DATE:	February 9, 2021	RWDI REFERENCE #: 1904405
TO:	Anthony Witherdin	Director, Key Sites Assessments - DPIE
FROM:	Kevin Peddie	Email: kevin.peddie@rwdi.com
	Michael Pieterse	michael.pieterse@rwdi.com
RE:	Solar Access – City of Sydney Review Response Waterloo Metro Quarter – Building 2

It is understood that after submission of the planning documents for the Waterloo Metro Quarter development, commentary has been provided on the submission. The comments received are noted below, with commentary in response discussed in this memo. This document is an addendum to the submitted Appendix OO – Solar Access report for Buildings 2.

SOLAR ACCESS

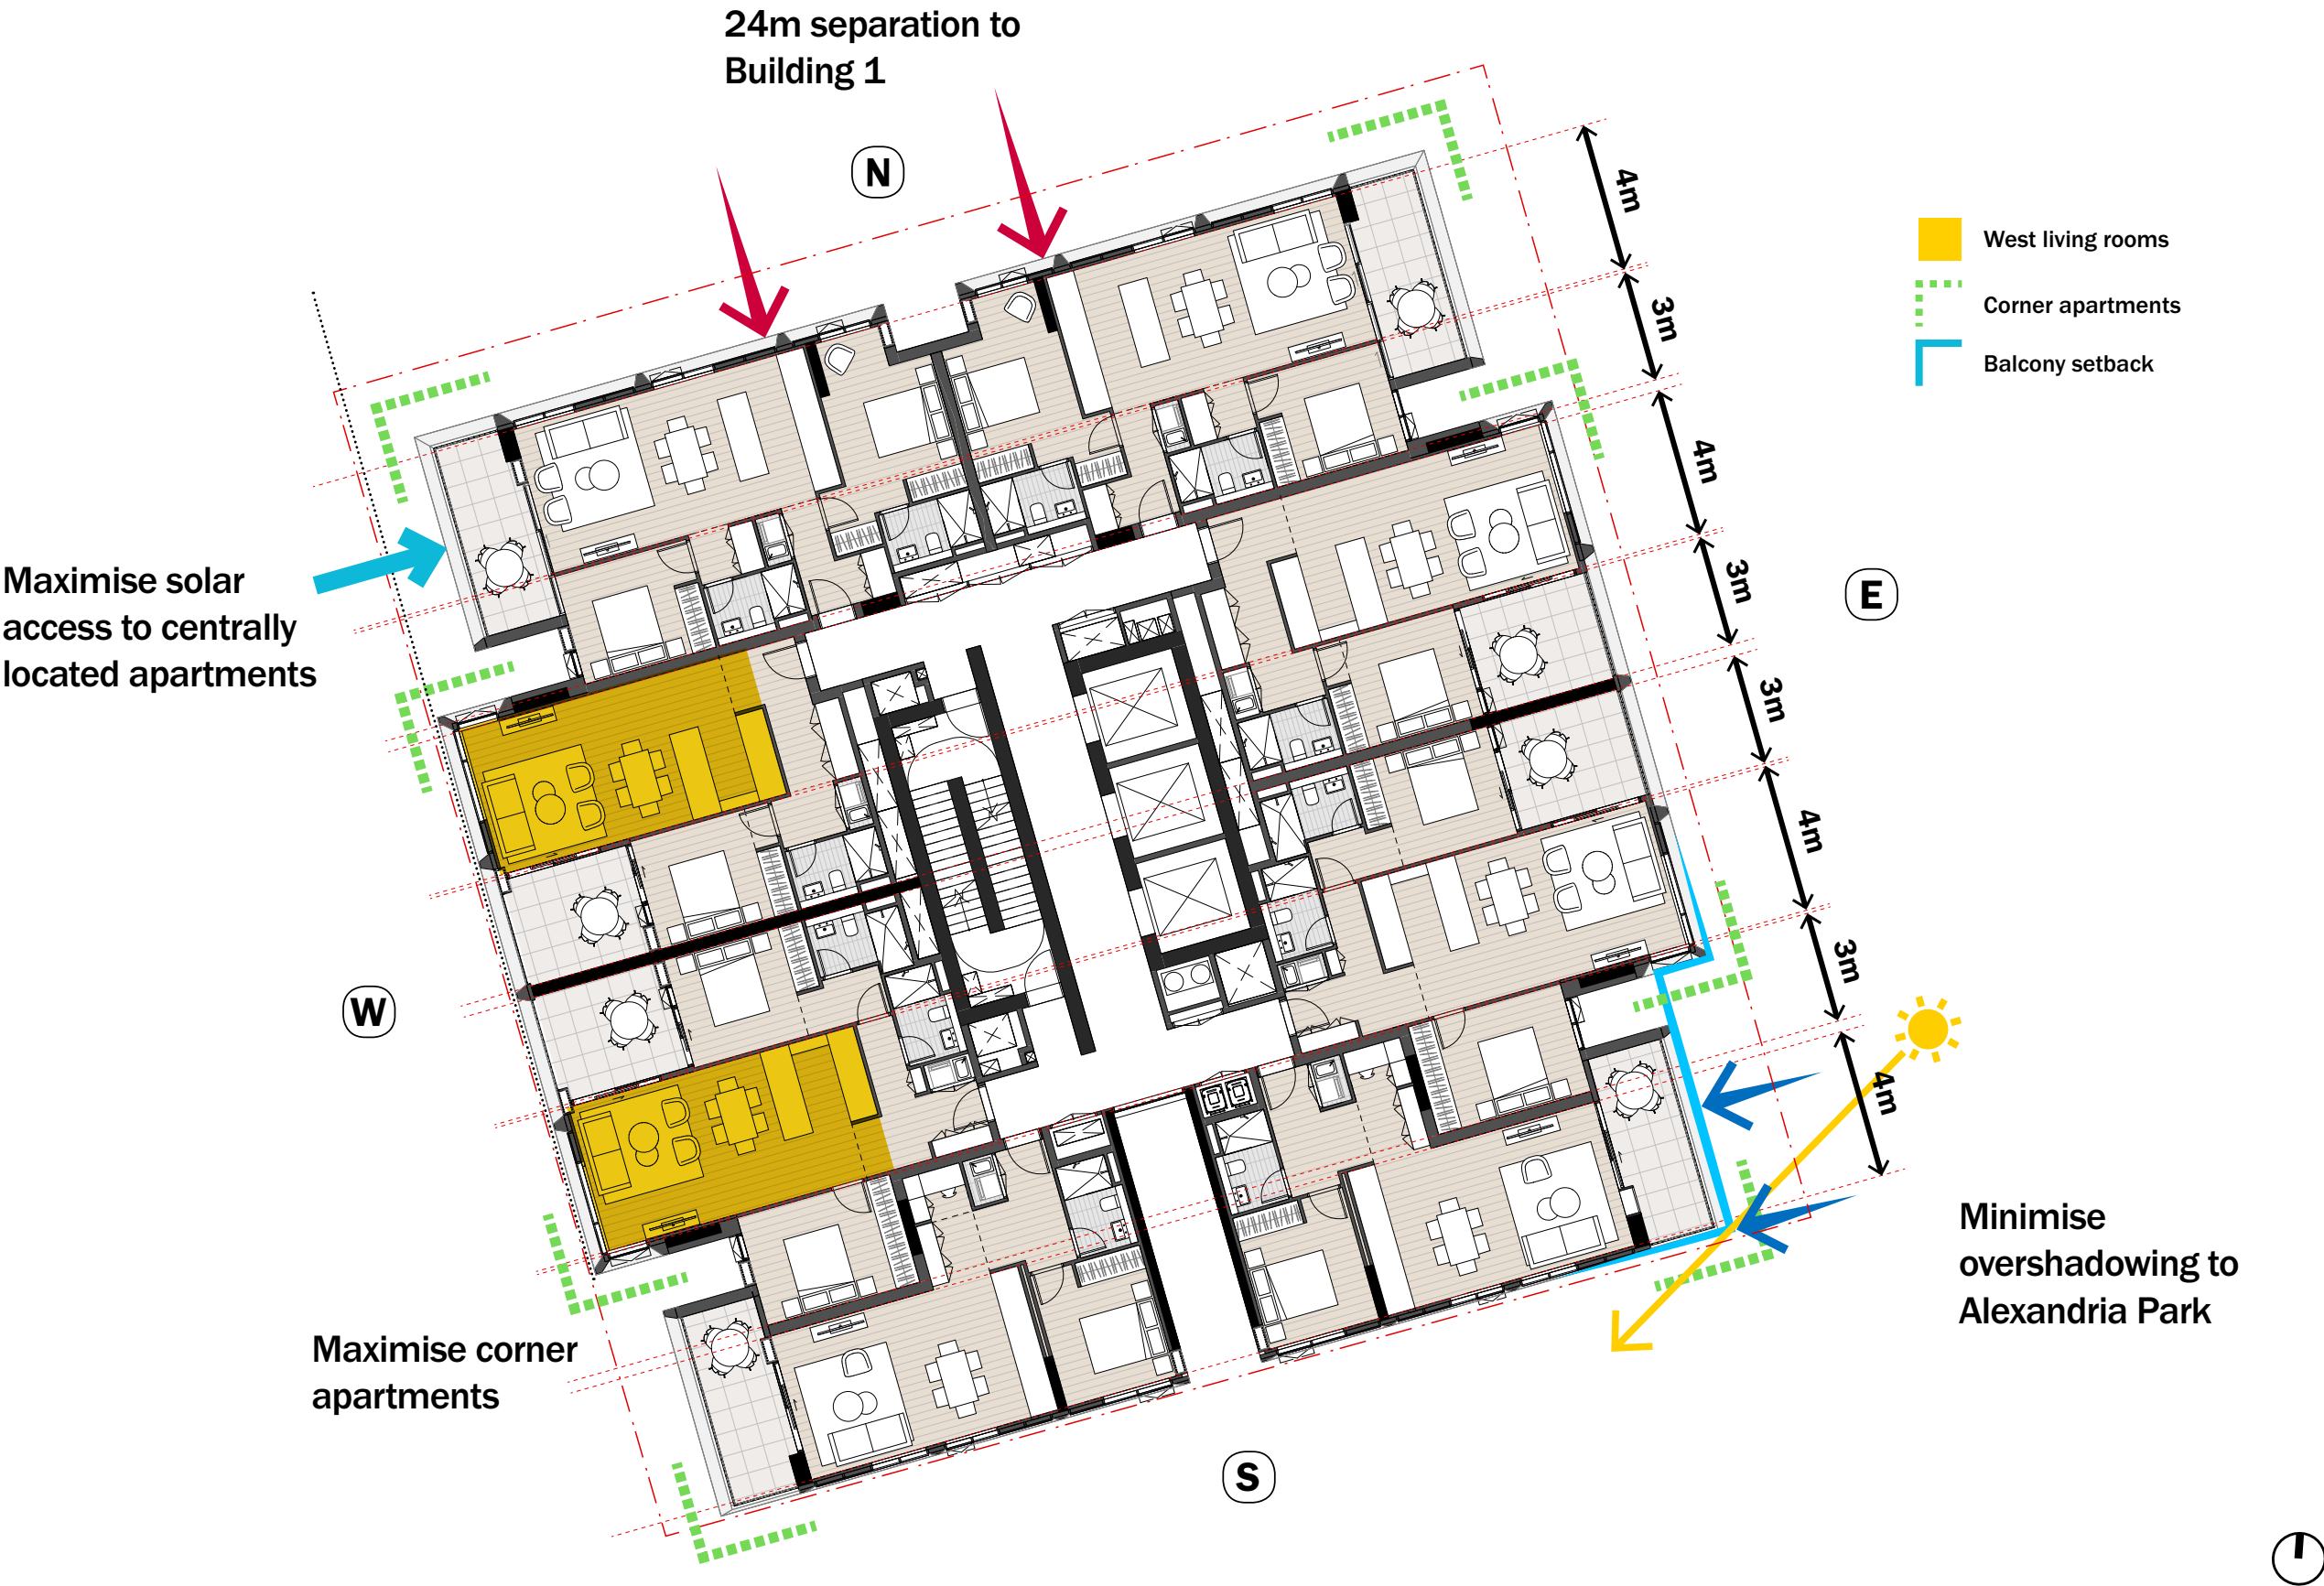
Solar access – Objective 4A-1 of the Apartment Design Guide (ADG) recommends, as a minimum, 70% of apartments be provided solar access to living rooms and balconies for at least two hours during midwinter. The application states that 57% of apartments achieve the design criteria. The City does not support the applicant's justification for the non-compliance by including solar access after 3pm as this is not reflected in the design guidance or criteria and is of little thermal benefit due to the low altitude of the sun.

No information is provided to illustrate alternatives to achieve compliant solar access within the widely accepted criteria (9am to 3pm) such as staggering the floor plate to allow sun ingress from 1pm. Winter sunlight is generally discounted outside 9.00am-3.00pm as it is of little thermal benefit due to the low altitude of the sun. The more detailed solar information in the architectural design report demonstrates that even at 1.30pm, sunlight is too oblique to the facade and there is no benefit to extending the assessment criteria:

The tally incorrectly includes apartments as complying where only the living room glazing meets the criteria, rather than both living room glazing and balcony. This is not a correct interpretation of the ADG, which requires both to achieve a minimum of 2 hours of sunlight in order to be counted in the minimum 70% of apartments. This applies to both west facing apartments, and apartments at lower levels in the northeast corner of the plan, which are shaded by the southeast corner of Building 1. These apartments have been counted where

only the balcony achieves the minimum amount of sunlight (loss of 3 apartments). The stated solar access tally is incorrect and should be updated to reflect a correct interpretation of the ADG design criteria. It is likely to be well below the minimum when measured correctly.

A Solar Access Study was undertaken for the residential apartments associated with Building 2 of the development. Section 8 – Assessment and Findings, of the report outlined the results of the modelling, noting the number of apartments which will have access to direct sunlight on June 21 between 9:00am and 3:00pm. The results provided an initial summary of the number of apartments which satisfied both direct sunlight to the living space as well as the private outdoor area, as well as a breakdown of each component. For Building 2, this was further broken down to note the number of living spaces which had access to direct sunlight and number of private outdoor spaces, in isolation to each other and is summarised below for reference.

Number of Apartments	Assessment Scenarios between 9:00am and 3:00pm
57% (85 out of 150)	Apartments which receive at least 2hrs of sunlight access to the living space windows AND private outdoor areas
65% (97 out of 150)	Apartments which receive at least 2hrs of sunlight access to the living space windows
59% (89 out of 150)	Apartments which receive at least 2hrs of sunlight access to the private outdoor areas

Number of Apartments	Assessment Scenarios between 9:00am and 3:30pm
80% (120 out of 150)	Apartments which receive at least 2hrs of sunlight access to the living space windows AND private outdoor areas
80% (120 out of 150)	Apartments which receive at least 2hrs of sunlight access to the living space windows
87% (130 out of 150)	Apartments which receive at least 2hrs of sunlight access to the private outdoor areas

The alternative design options considered by the architect have been addressed in a separate design addendum document prepared by the project architect.

As noted in the response to submission prepared by the project architect, the Stage 1 Concept Plan noted a number of apartments which do not have access to direct sunlight due to the apartment primarily being located on the northern or southern aspect of the tower. The proposed scheme has positioned the apartments on the eastern and western aspect, significantly improving the overall amenity of the apartments for the building.
